**Comments on any additional submissions received by Deadline 5**  
**ELMESTHORPE PARISH COUNCIL**  
**19<sup>th</sup> February 2024**

1. Introduction

**ES FIGURE 14.5 - MAIN HRFI SITE
CONCEPT FOUL WATER DRAINAGE STRATEGY**

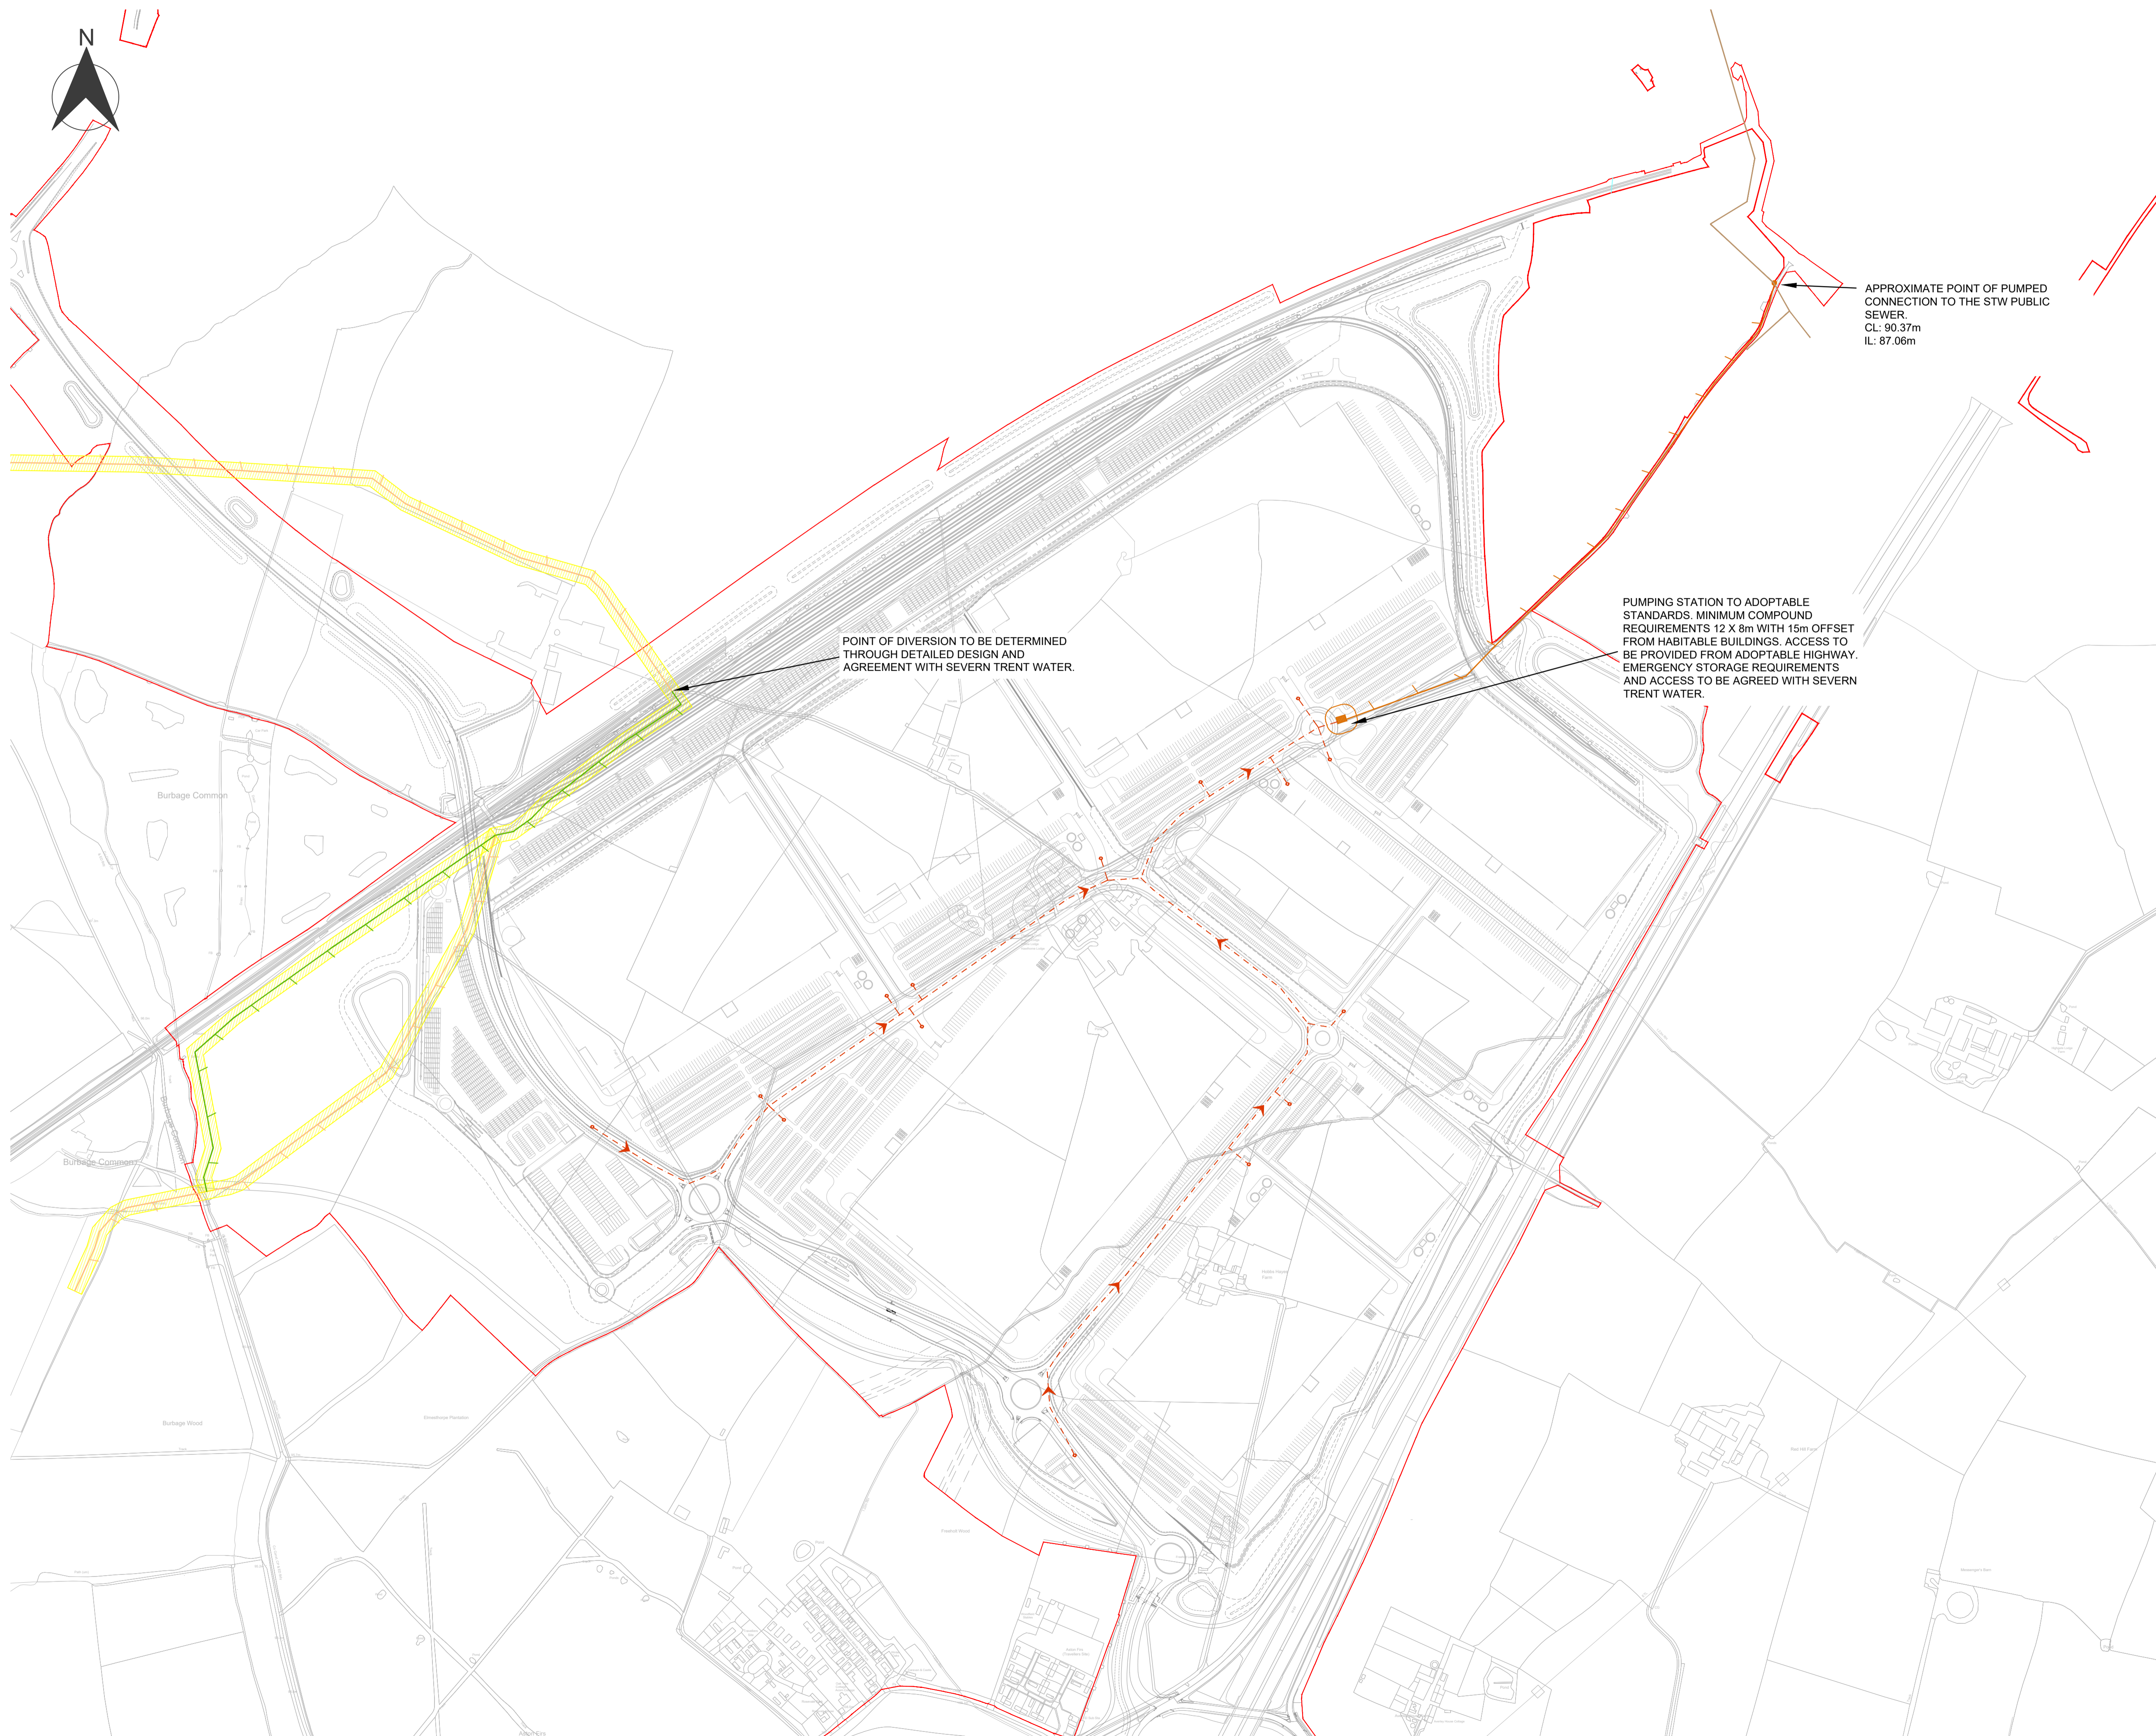
- 2.3. Elmesthorpe Parish Council do not dispute that the public sewer system is the responsibility of STW. We wished to raise the frequent issues that we currently experience in the village, to highlight the fact that STW will need to do considerable work to ensure the system can accommodate the additional sewage/drainage requirements of the proposal.

- 2.4. The pumping station in Bostock Close is immediately next to residential homes. When the pumping station is being worked on by STW it causes direct disruption to residents and impacts those working from home, sleep and general enjoyment and amenity of homes and gardens.

- 2.5. The main sewer line that services the majority of the village runs parallel to B581 Station Road, from the A47 Clickers Way to Bostock Close pumping station, and is only accessible via entry to resident's rear gardens along Station Road. Any work required to the main sewer line will directly impact residents and include disruption and potential damage to private property.

- 2.6. Similarly in situations where the foul drainage system is overwhelmed, it will directly impact those residents along Station Road B581 and Bostock Close.

- 2.7. Elmesthorpe Parish Council agrees with the Applicant that STW will need to undertake mitigation works to deliver an effective solution. We ask that the Examining Authority considers the extra disruption that residents will face as a result of the essential work that STW will need carry out, that will be directly associated with accommodating the HNRFI proposal should it be approved.
